Office of
Environment
& Heritage

Your reference: SSD 9098
Our reference: DOC18-764481
Contact: Simon Stirrat
Ph 03 50516218
Date: 7 November 2018

RE: Sebastopol Solar Farm (SSD 9098) – Exhibition of Environmental Impact Statement

Figure 9. Development footprint.

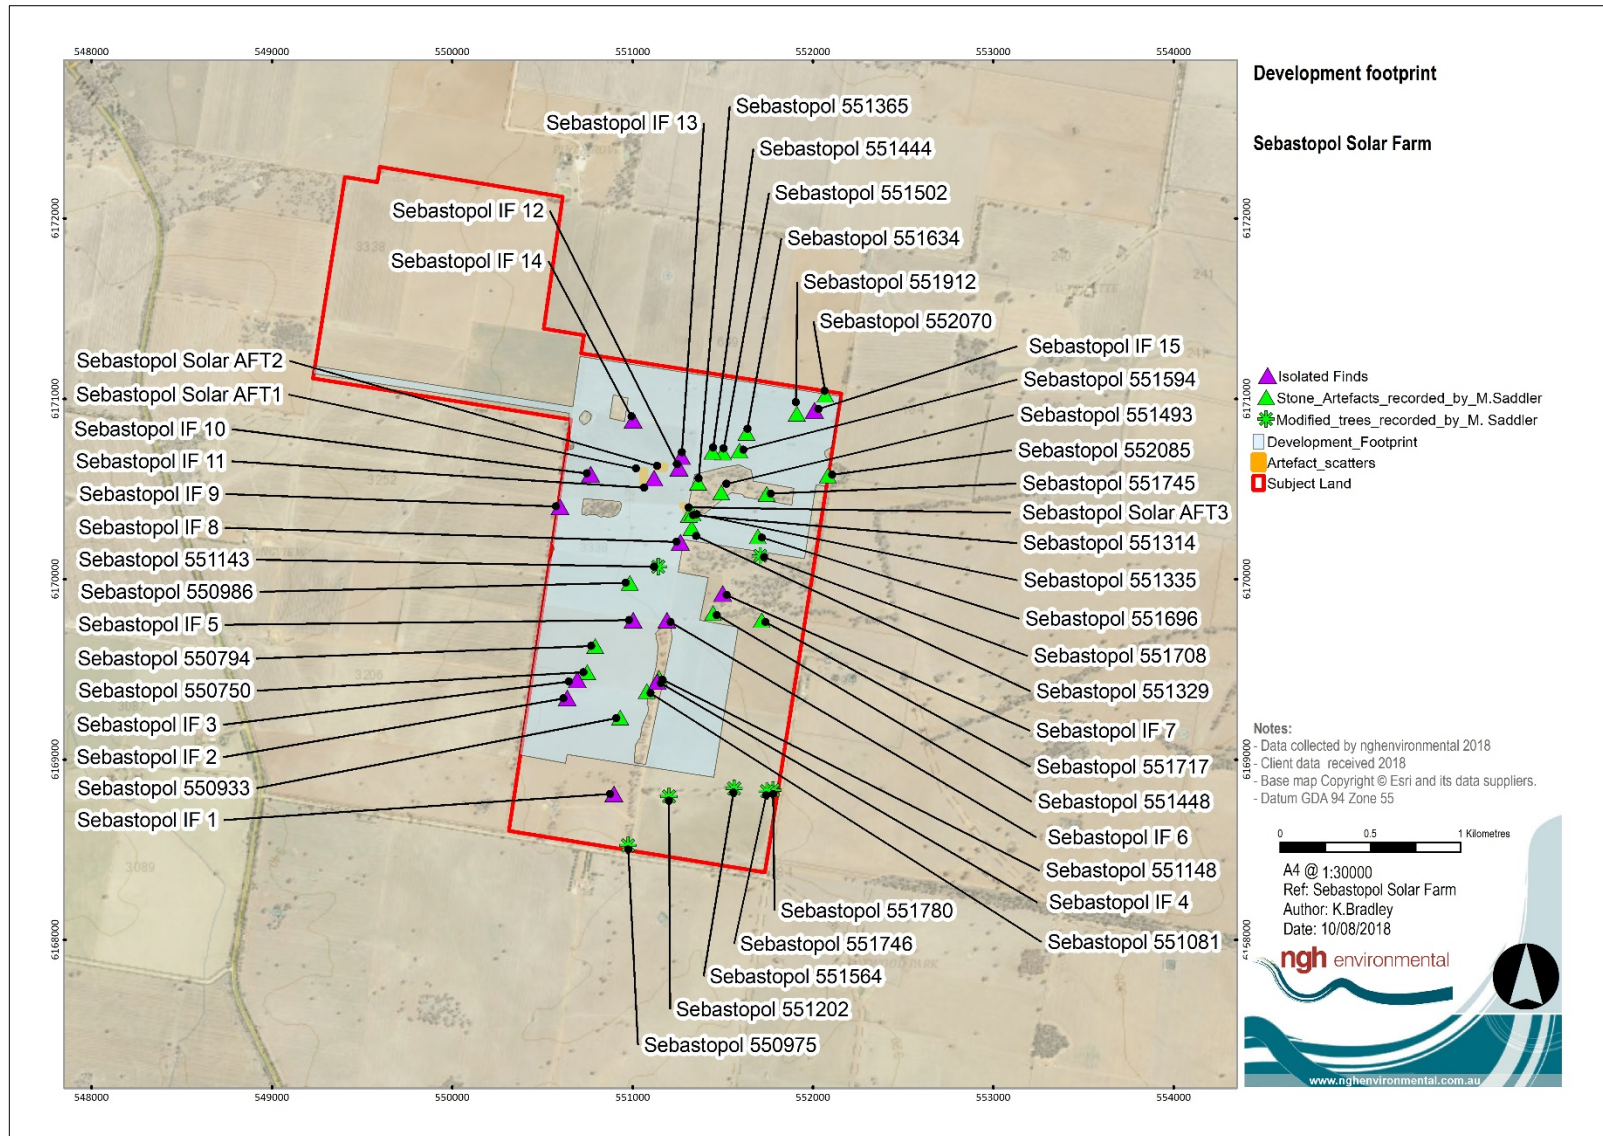
| 3 | <i>Issue</i> | 10 m buffer for scarred trees. <i>Recommended action</i> Larger trees may require buffers greater than 10 m to ensure protection of the canopy and to consider below ground impacts to the root system. Buffers may be determined on a tree by tree basis. Consideration could be given to seeking specialist advice from an arborist or ecologist regarding buffers to ensure protection of the trees. |

- Recommendation 1 and Table 8 – recommends a minimum 10 m a buffer of be provided around scar trees. Larger trees may require buffers greater than 10 m to ensure protection of the canopy and to consider below ground impacts to the root system. Buffers may be determined on a tree by tree basis. Consideration could be given to seeking specialist advice from an arborist or ecologist regarding buffers to ensure protection of the trees.
- Recommendation 2 - salvage can only occur following development consent and prior to works commencing.
- Recommendation 3 – an Aboriginal Site Impact Recording Form must also be completed and submitted to AHIMS for each site harmed or destroyed from salvage and construction works.
